Project Name: C. N. Brown Company Gas Station Site Improvements
Project ID: # 2014-021
Address: 194 Auburn Street
CBL: 374 A030 001
Applicant: C. N. Brown Company
Planner: Jean Fraser

On April 10th, 2014, the Planning Authority approved with conditions a Level I: Site Alteration site plan for the implementation of improvements associated with the conditional rezoning of the gas station at 194 Auburn Street. The proposals include narrowing of the curbcuts, crosswalk markings and planting, as shown in the submitted plans dated March 4, 2014 prepared by Site Design Associates.

DESIGN:	TWS	PROJECT:	EXISTING SERVICE STATION
DRAWN:	DEPT.		194 AUBURN STREET PORTLAND, MAINE
CHKD:	TWS		CONCEPTUAL SITE PLAN
DATE:	JUNE 2013	PROJ. NO.:	
SCALE:	1"=20'	DWG. NO.:	
		REV.:	C

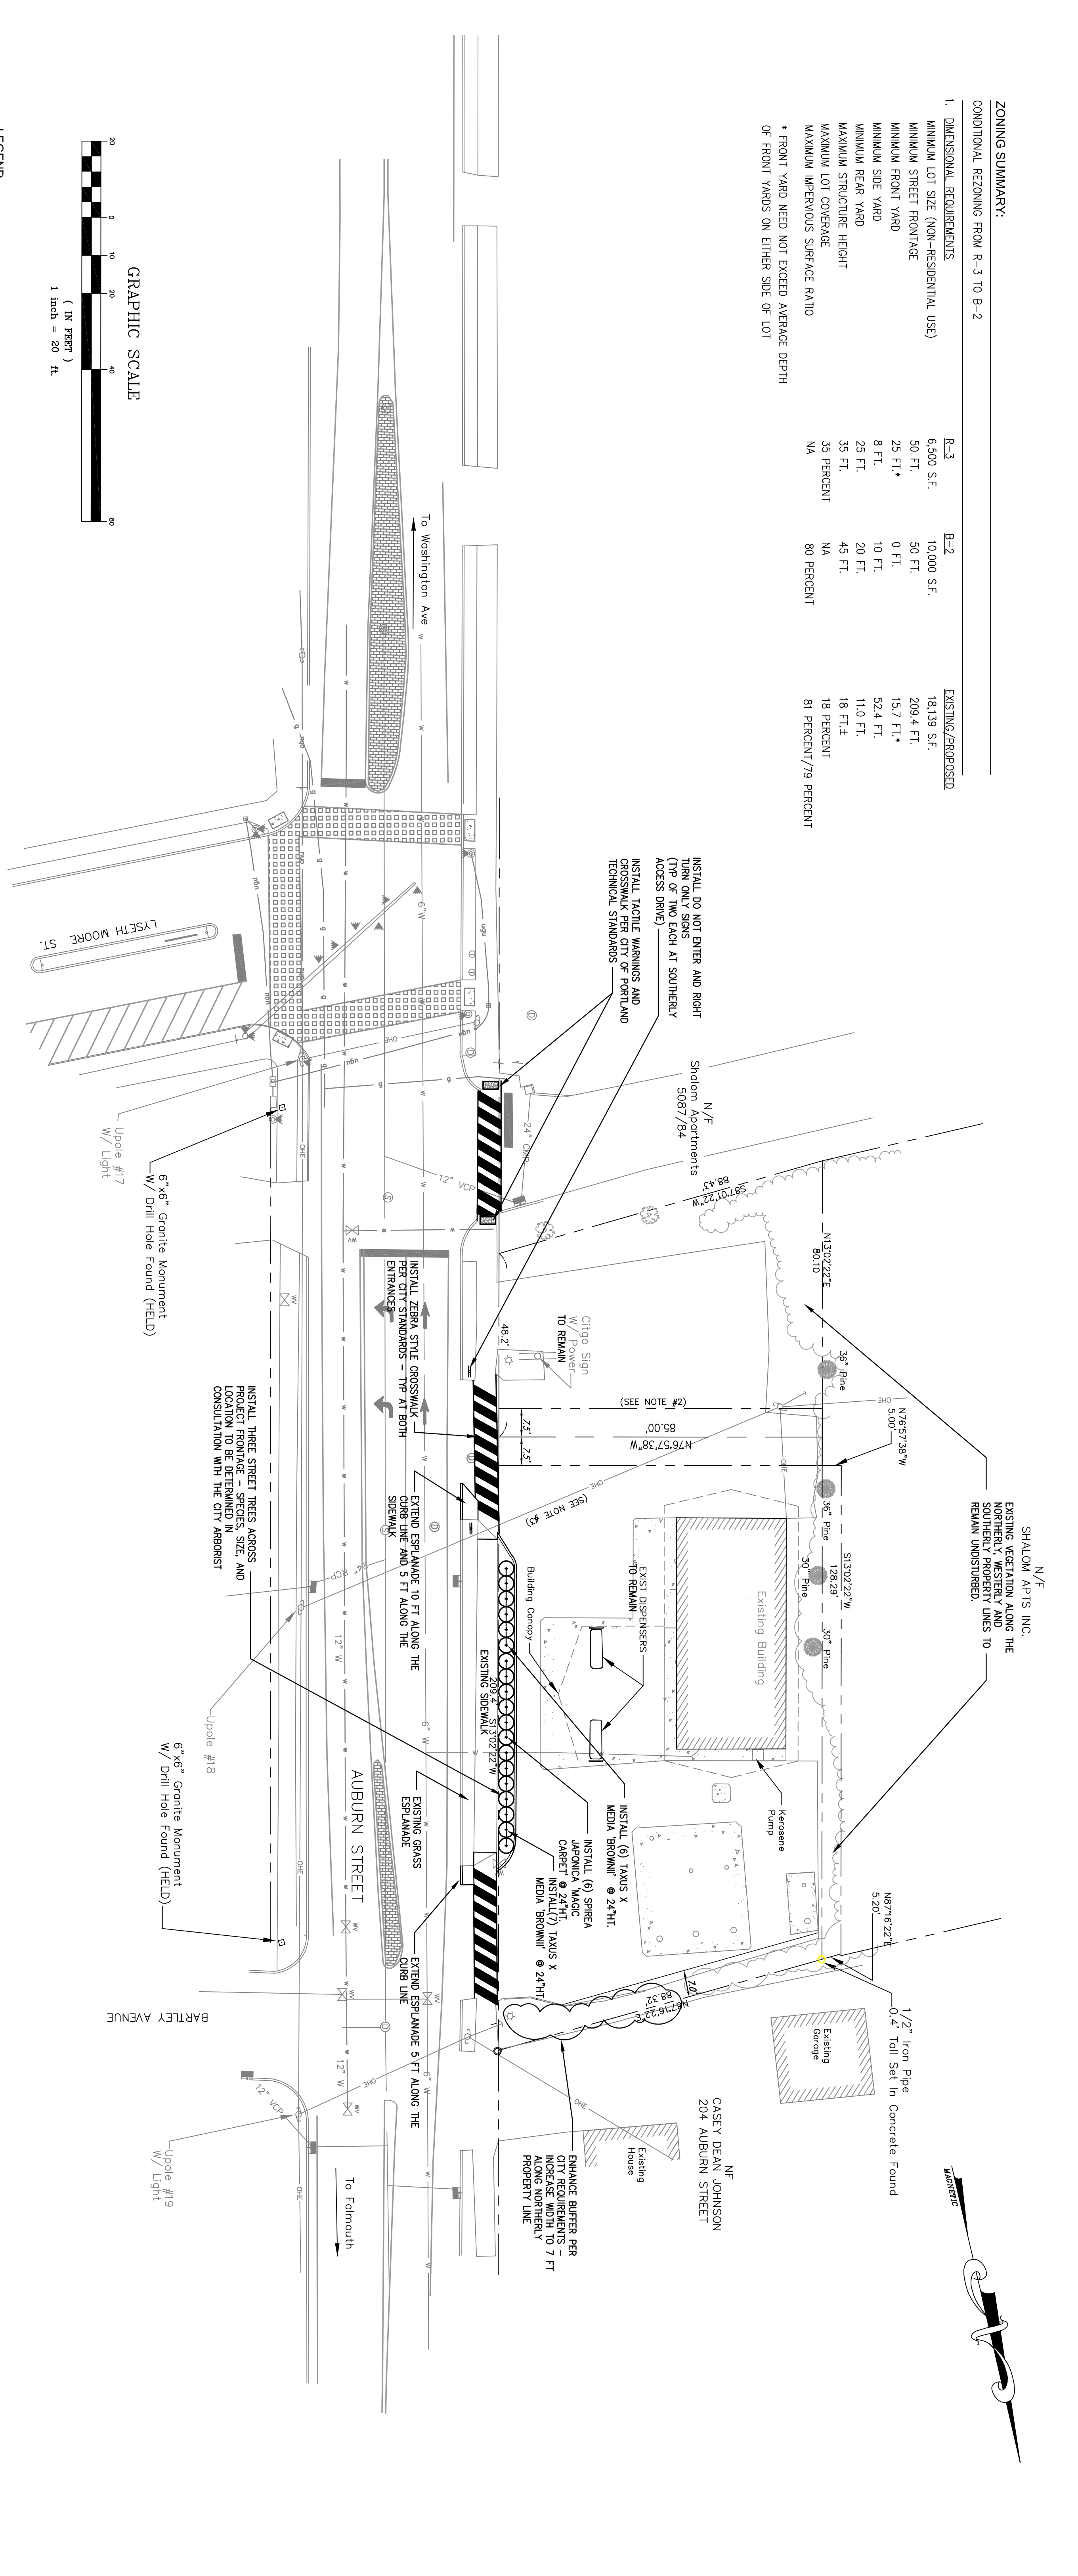
1. The applicant shall revise the plans C-101; C-102 and C103, for review and approval prior to the issuance of a building permit, to: a) show or note catch basin inlet protection (silt sacks) to be installed at the first down-gradient catch basin in Auburn Street during construction; b) add a note that states that the Auburn Street Right-of-Way shall be kept clean from dust and construction debris and swept daily or as requested by the City of Portland to minimize dust and sediment originating from the site; c) show monument corners to be set and indicate ownership of the rectangle parcel of land indicated along the back property line; and
